From: **Marc Daley** <Marc.Daley@environment.nsw.gov.au>
Date: Tue, Sep 8, 2020 at 11:00 AM
Subject: RE: Moonee SSD 7198
To: Jason Wasiak <jason@jwplanning.com.au>
Cc: Emma Butcher <Emma.Butcher@planning.nsw.gov.au>, Krister Waern
<krister.waern@environment.nsw.gov.au>

From: Jason Wasiak <jason@jwplanning.com.au>
Sent: Monday, 7 September 2020 3:22 PM
To: Marc Daley <Marc.Daley@environment.nsw.gov.au>
Cc: Emma Butcher <Emma.Butcher@planning.nsw.gov.au>; Eric Fuller <e.fuller7@icloud.com>; Kerry Albert <kerry.albert@uniteadvisory.com.au>
Subject: Moonee SSD 7198

Subject: RE: Moonee SSD 7198

**Peak Water Level – 1 in 100 Year ARI With Climate Change  
Bucca Creek Flood (Scenario 10) Existing Conditions**

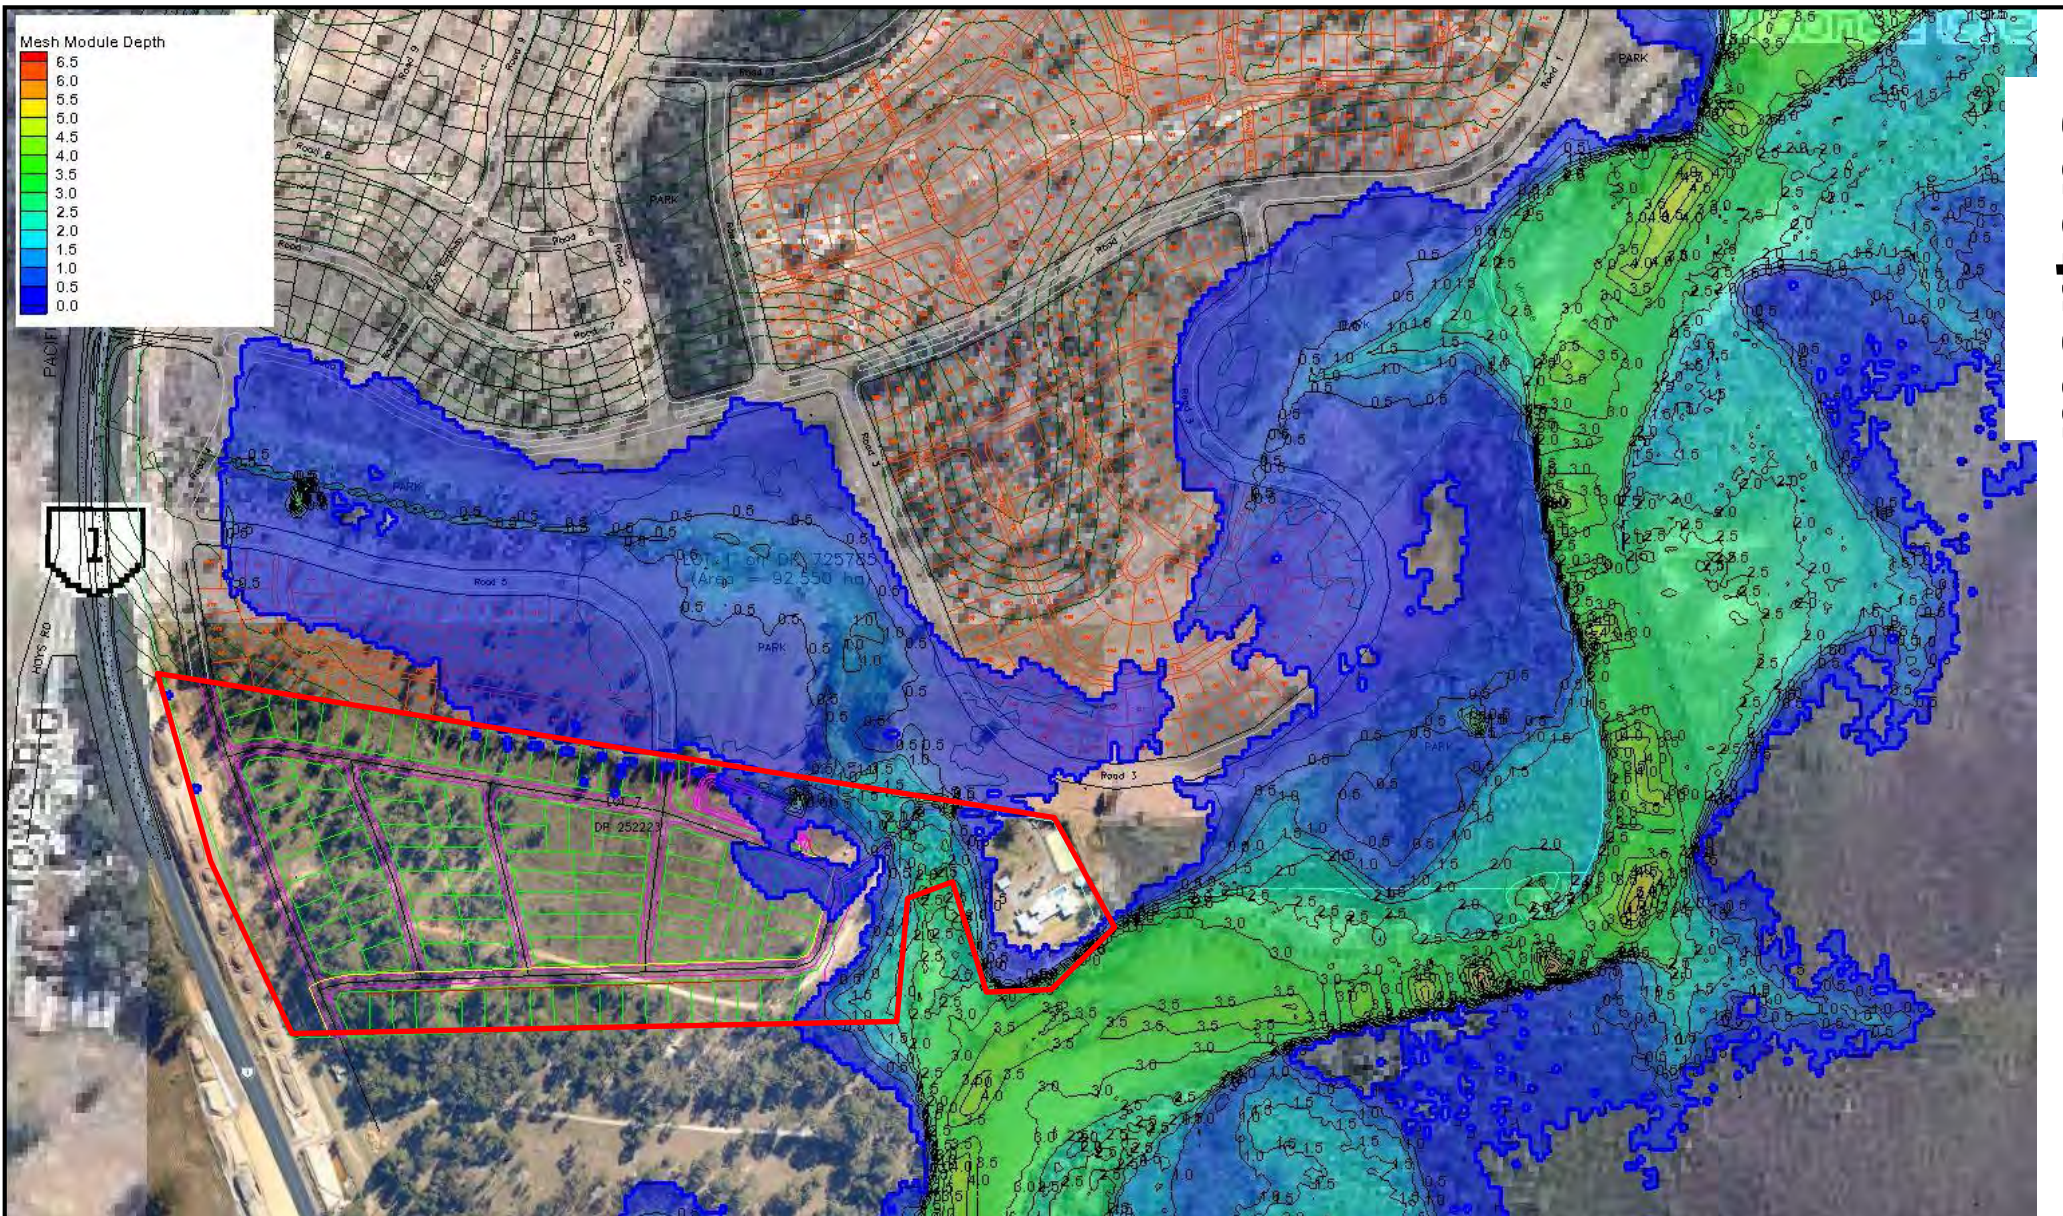
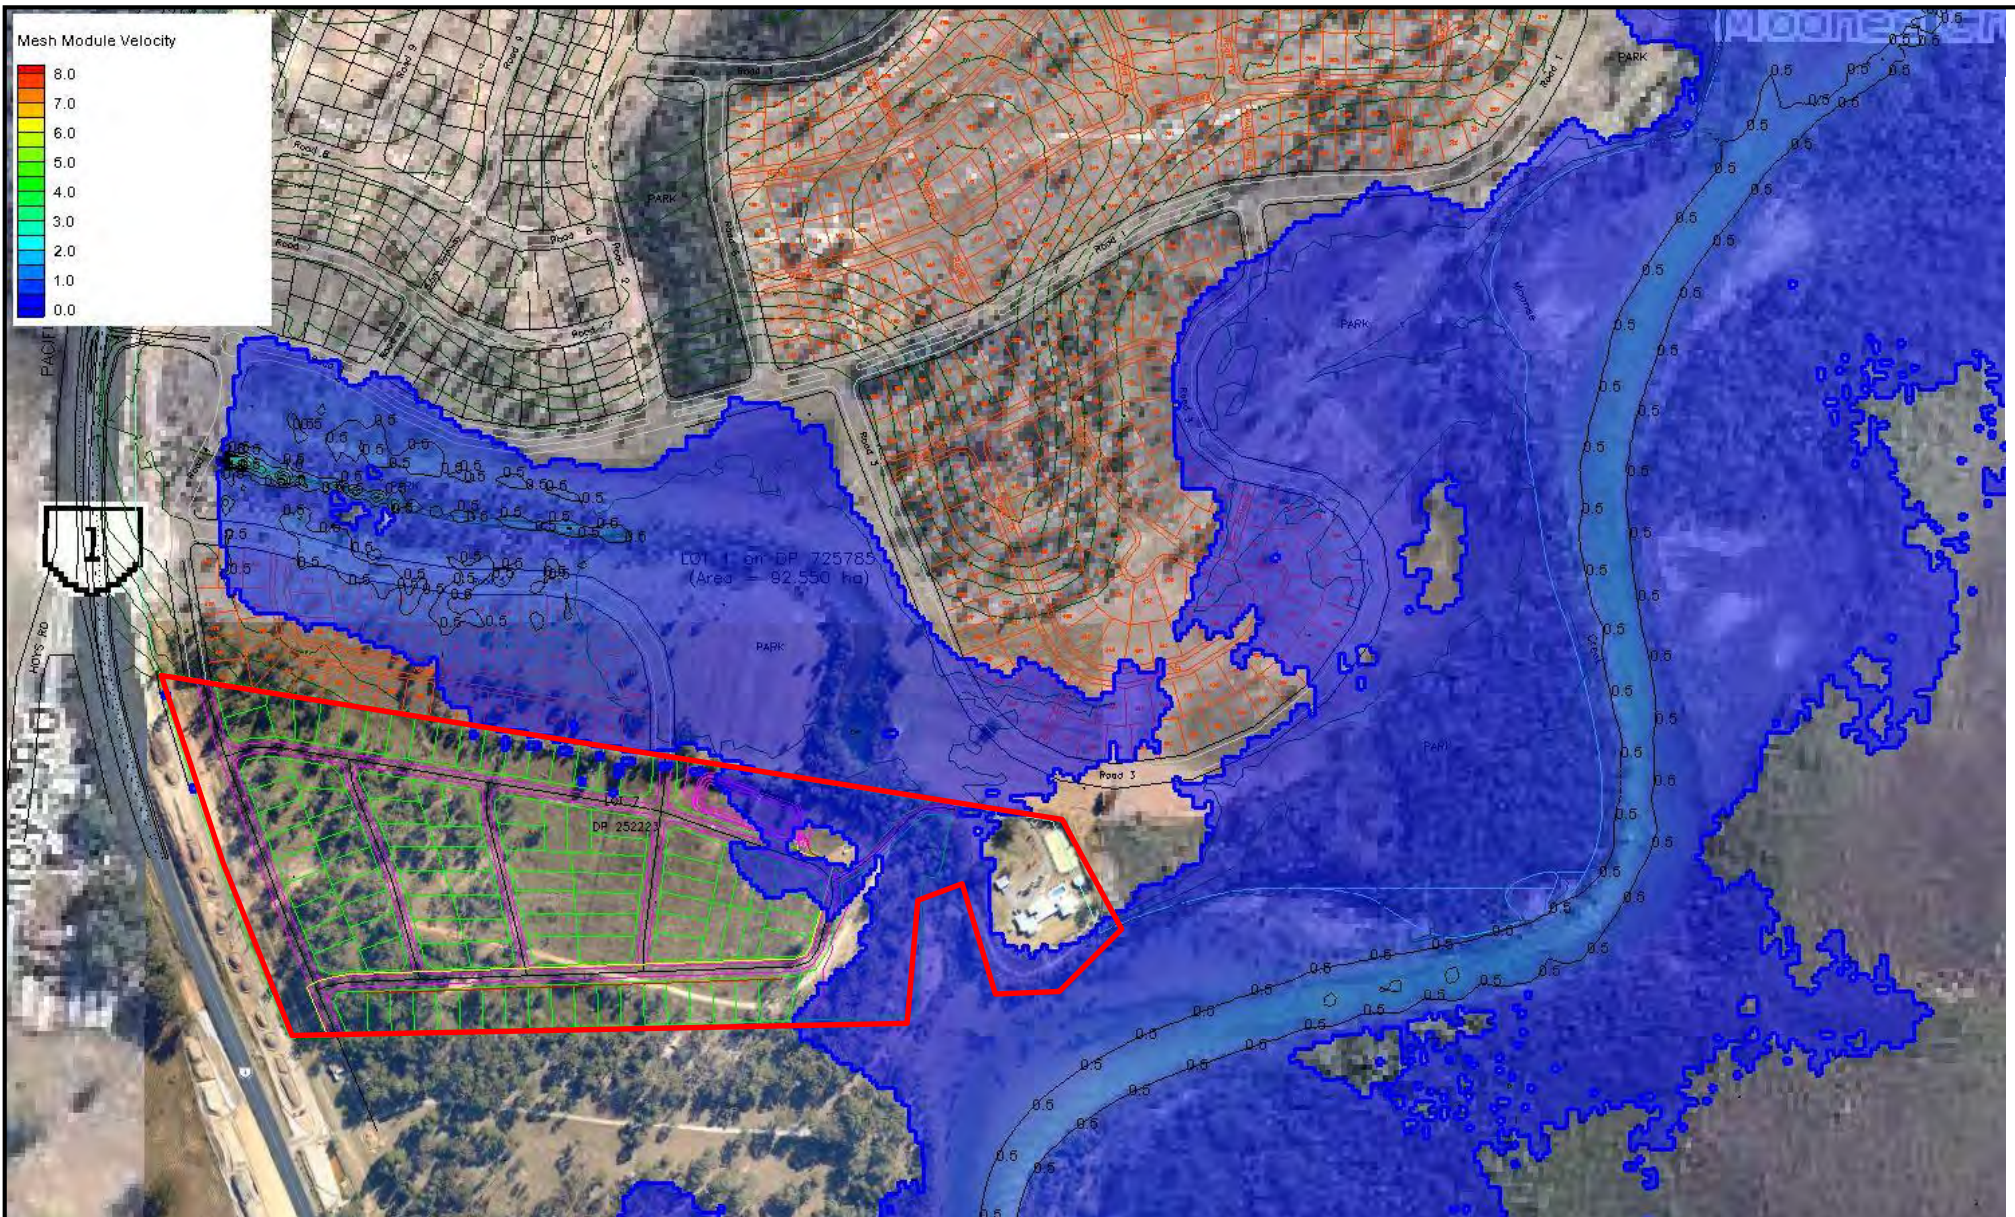
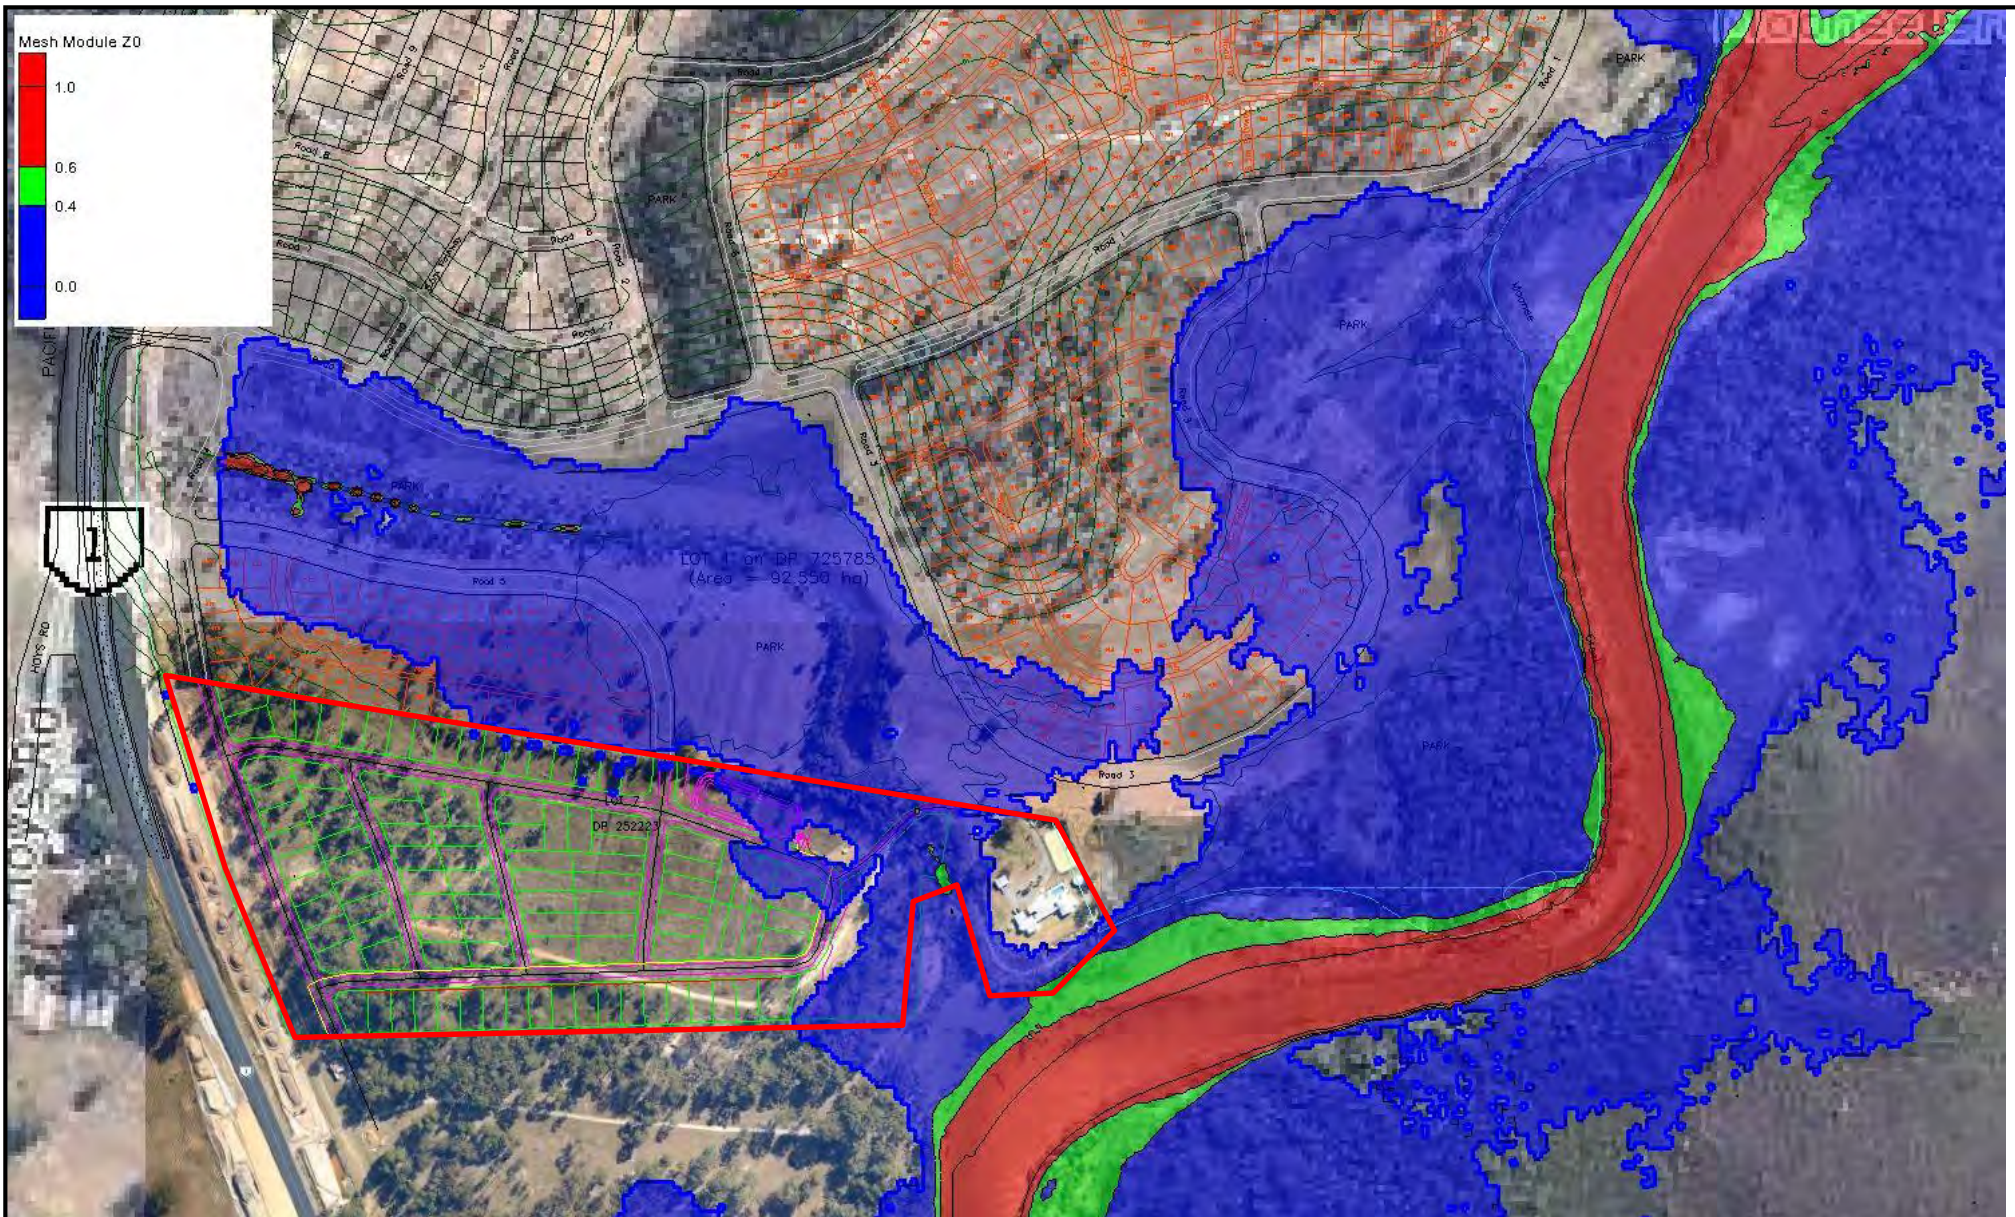
Please note the request wasn't for a 1% AEP flood and 1% AEP ocean water level to occur concurrently, per Jeff's reply. Only that proper consideration has been given to the tidal inundation through the ocean water level component, including the future impacts of projected climate change. From the flood modelling report initially provided, though scenarios 5 and 10 were listed, it wasn't clear how these scenarios were determined and the considerations given in relation to the ocean water boundary.

He is seeking clarification as to whether tidal inundation was included in the flood modelling. He said it was unclear from the data within the Marten's report.

He suggests that normally a 1% ocean water level + Sea Level Rise is factored into modelling, but believes this may not have been necessary if local catchment flooding is equal to or greater than ocean water flood level. Does this make sense to you, and can you please call me to discuss ASAP?

With reference to Section 3.2.3 of our flood assessment report, we have run various flood modelling scenarios. The worst case scenarios (5 and 10 in our report) assessed a 1% AEP flood with a 5% AEP climate change ocean level plus climate change of 0.91m (being 3.01 mAHD).

The BCD request for modelling a 1% ocean level plus 0.91m is contrary to the above. It also differs from the previous advice and discussions that we had with Council and WBM (experts acting on behalf of the Council). We note that applying BCD's request would mean modelling a very rare event, given that the 1% events for the flood and the inundation would need to occur concurrently. I expect this is why the various department guidelines noted above do not require such events to be modelled for design.

In light of the above, our flood assessment is considered satisfactory to assess impacts from tidal inundation and not further modelling is considered necessary.
